This application proposes the use of the former Ford Blockworks site to operate a materials recovery facility within an existing building on the site along with a residual waste treatment facility that would be housed within a new building.

This application is a County Matter waste application and will be determined by West Sussex. Arun is a consultee only and it is proposed that the wording within the conclusions section of the officer's report at page 25 of the agenda be incorporated into a letter in response to the consultation.

South Elevation

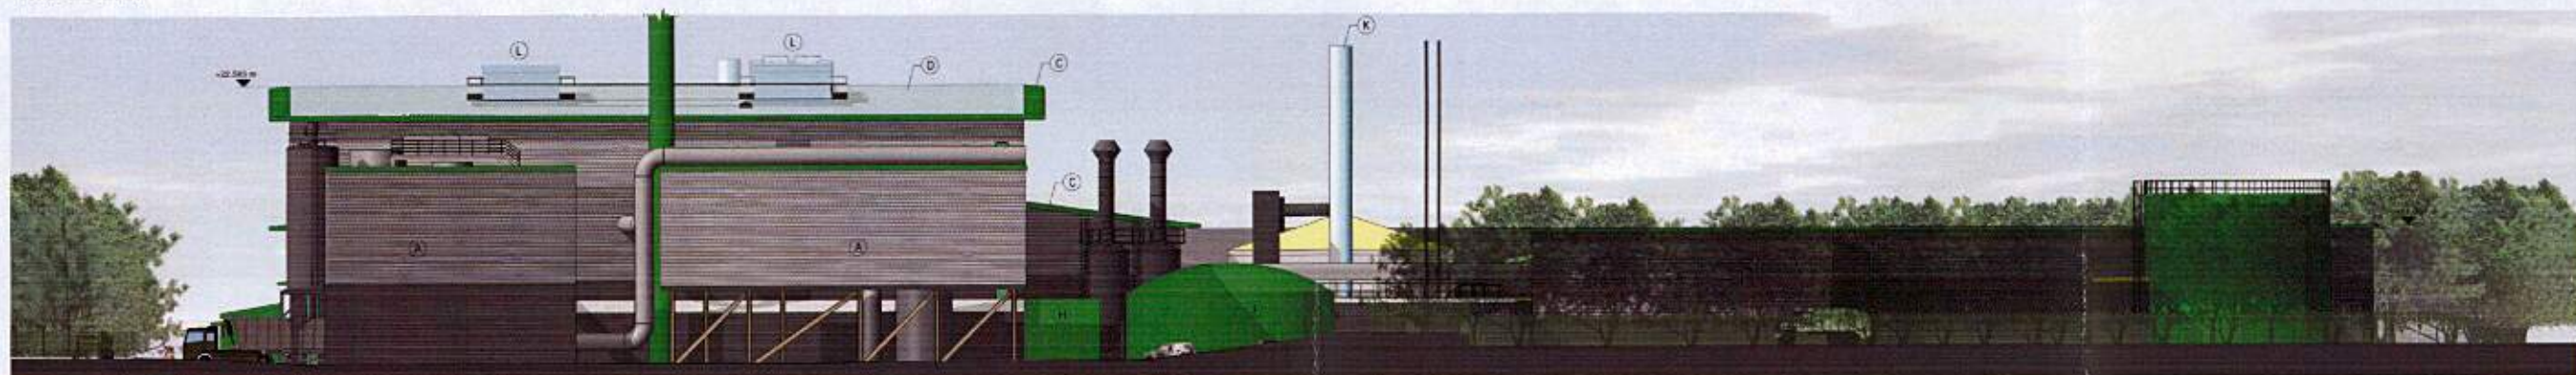
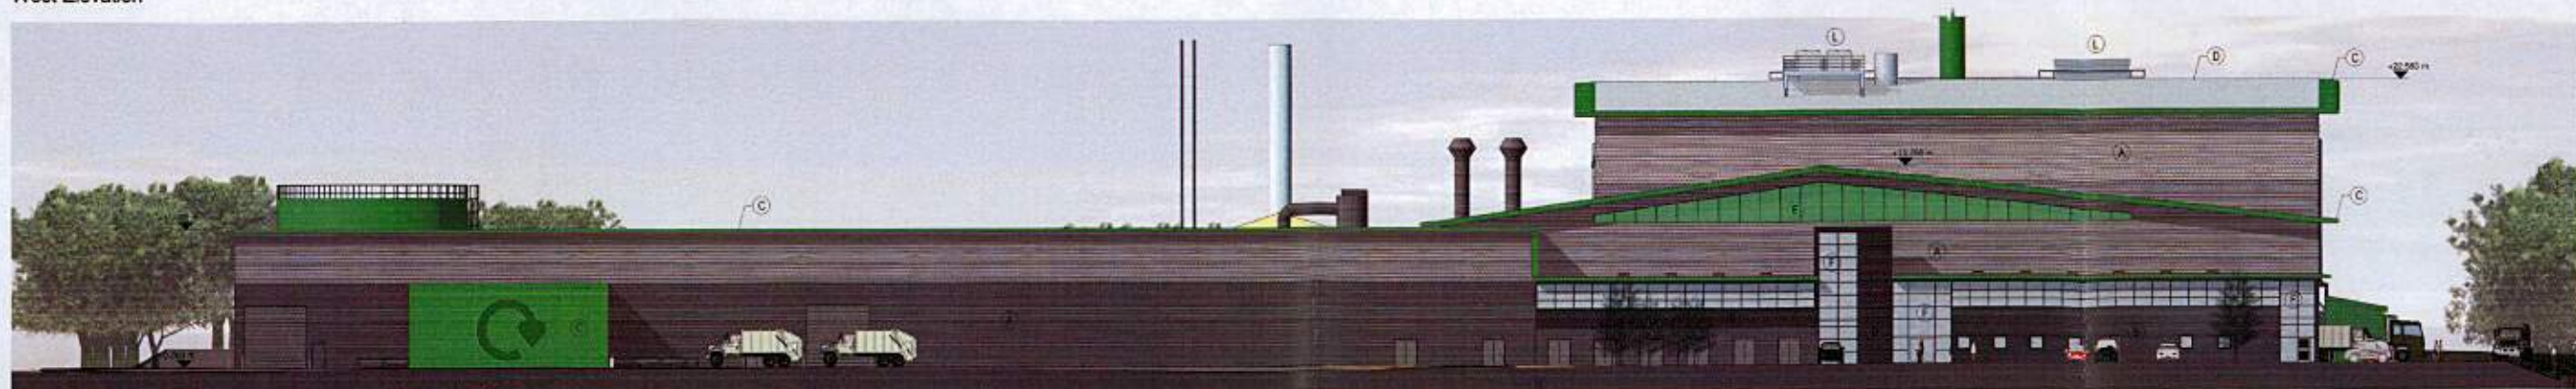
The elevations on screen identify the scale and position of the new building and flue stack, shown in orange together with the existing building on the site.

Officers recommend that an objection be raised to the scheme on two grounds. The first being noise as the current noise surveys are not reflective of the likely noise disturbances that would result from HGVs visiting the site and unloading waste. The second objection is to the height of the flue stack, due to the significant visual impact that would result and concerns over the justification for the height as set out in the *officer's* report.

Cllr Mrs Bower - Height of stack.
